Your ref:
Our ref: 23/00244/O
Please ask for: Amy Davies
Direct dial: 01553 616879
E-mail: borough.planning@west-norfolk.gov.uk

21 February 2023

Details: **Proposed 1.5 Storey Dwelling with New Access.
Proposed New Access to 1 Gaultree Square, Emneth. at 1 Gaultree Square
Emneth Wisbech Norfolk PE14 8DA**

Job Title Proposed Dwelling Land adjacent 1 Gualtree Square, Emmeth, PE14 8DA For: Ms J Hall	Date	Drawn by
	January 2023	BR
Drawing Title Outline Planning Drawing	Checked by	Sheet Size
	MC	A2
Job No.	Dwg No.	Revision
SE-1916	PP1000	A

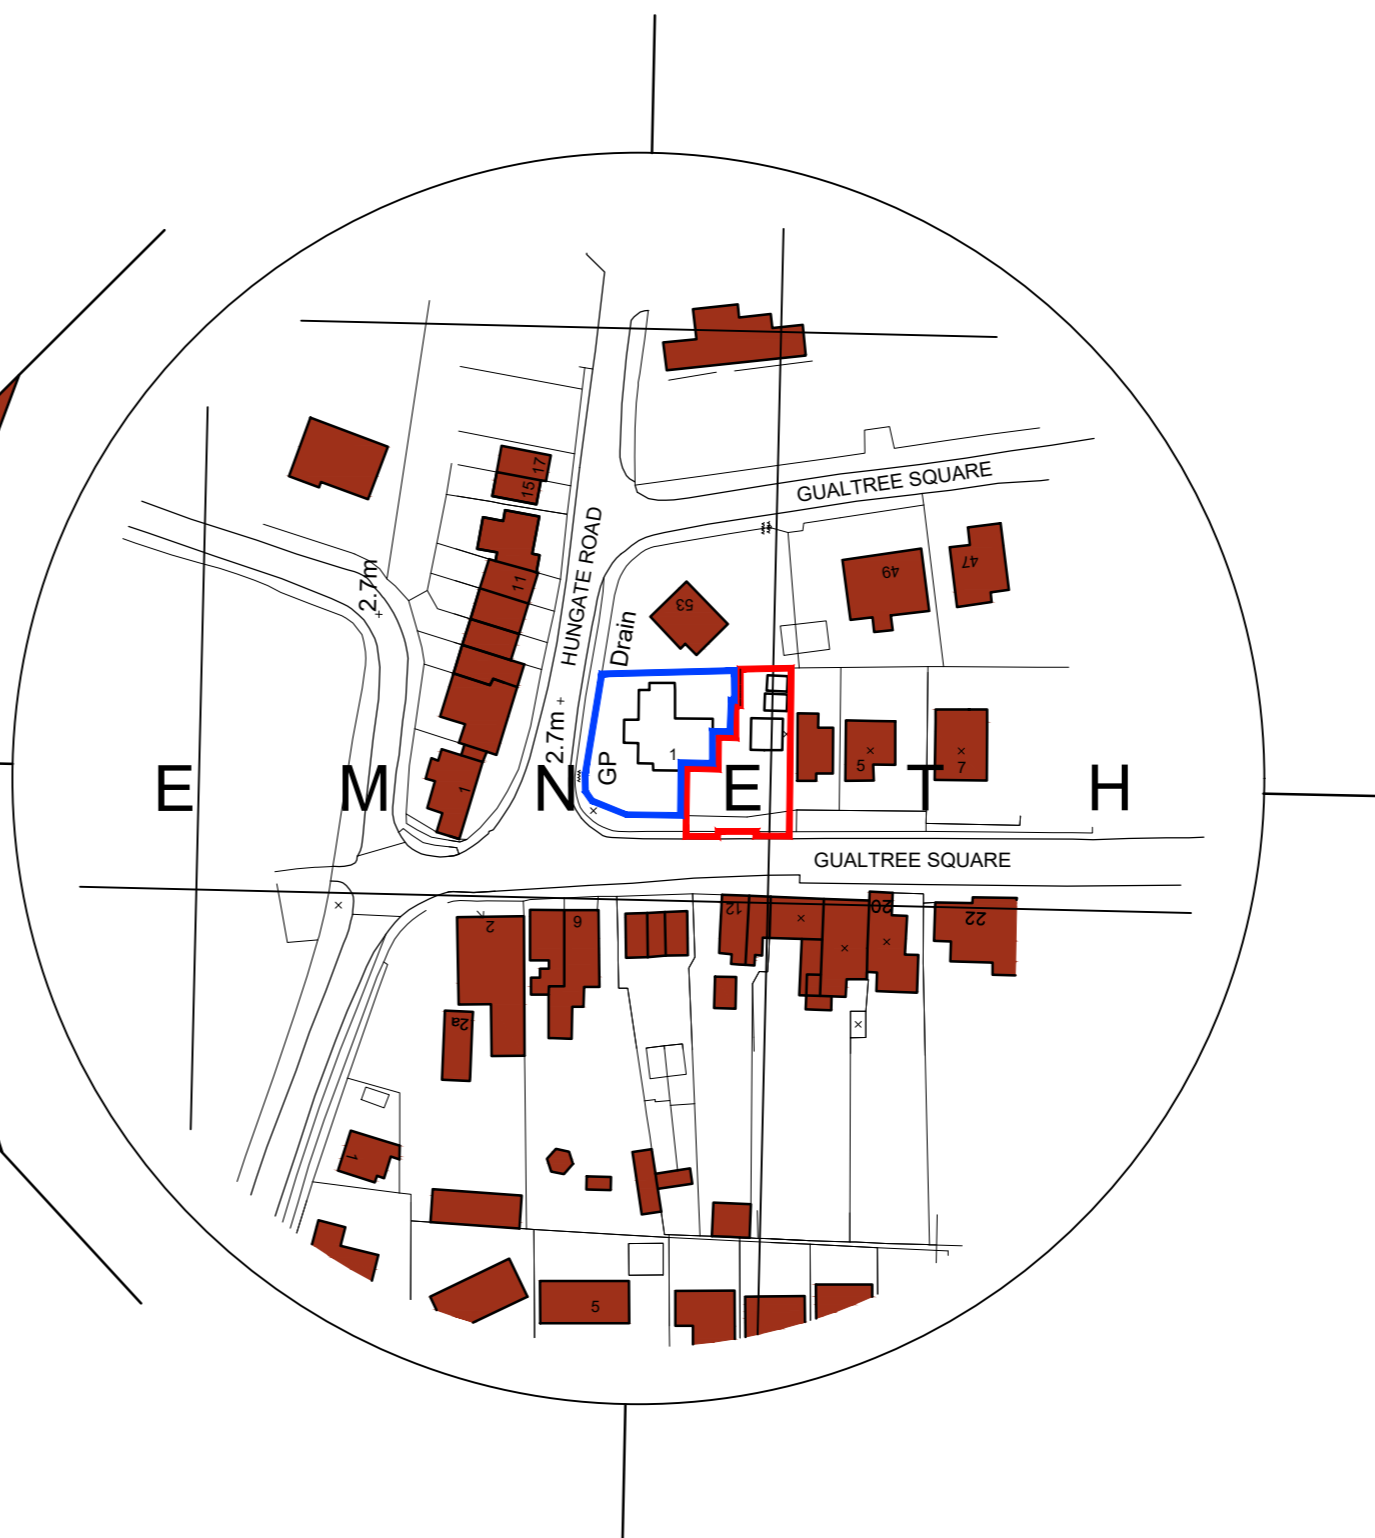
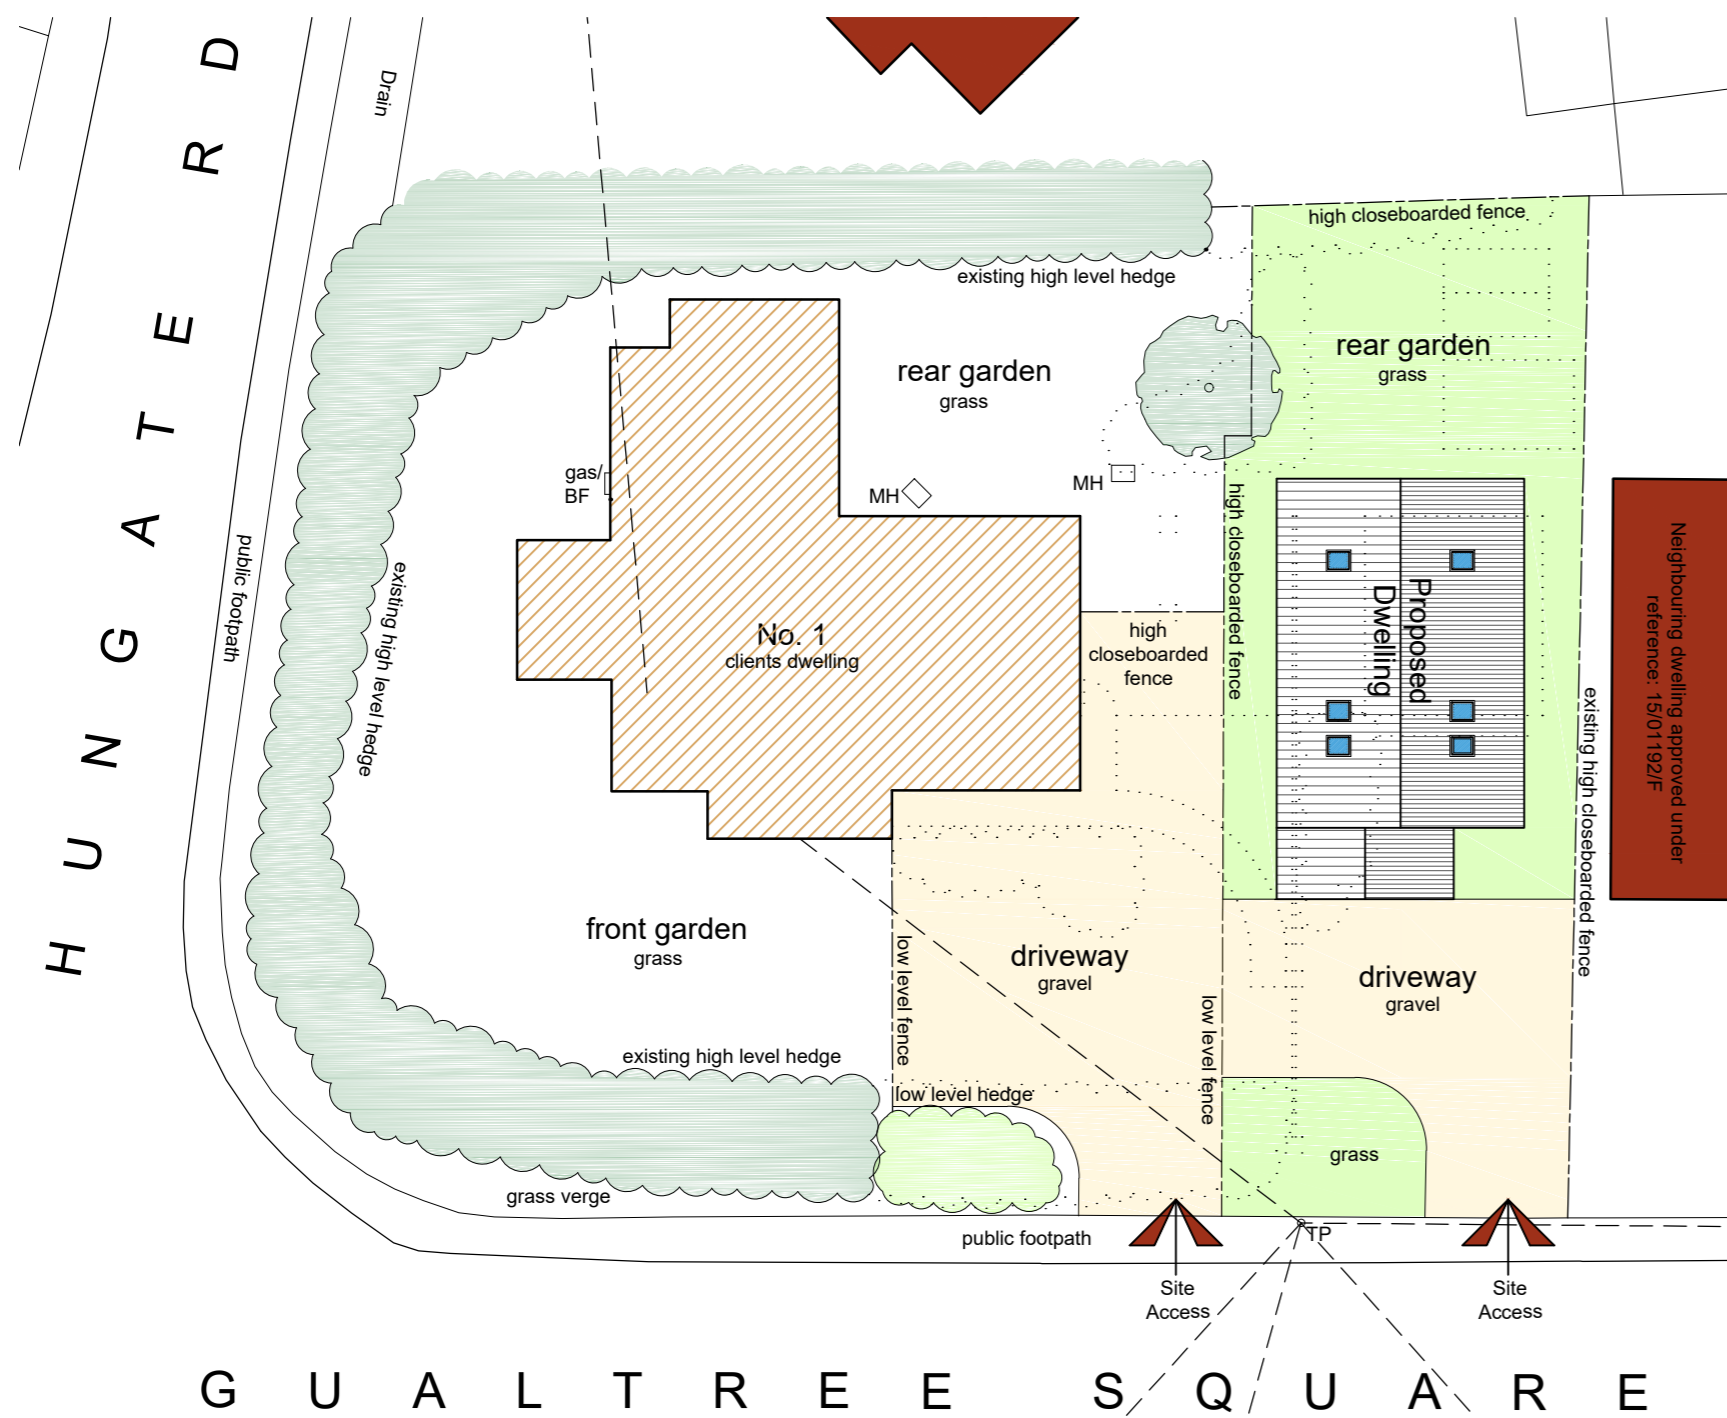
1. It appears you have chosen to reserve all matters with the application form submitted the plans show the access and sitting of the new dwelling but the plans are not marked as indicative if you wish to reserve these matters please label the plans accordingly .
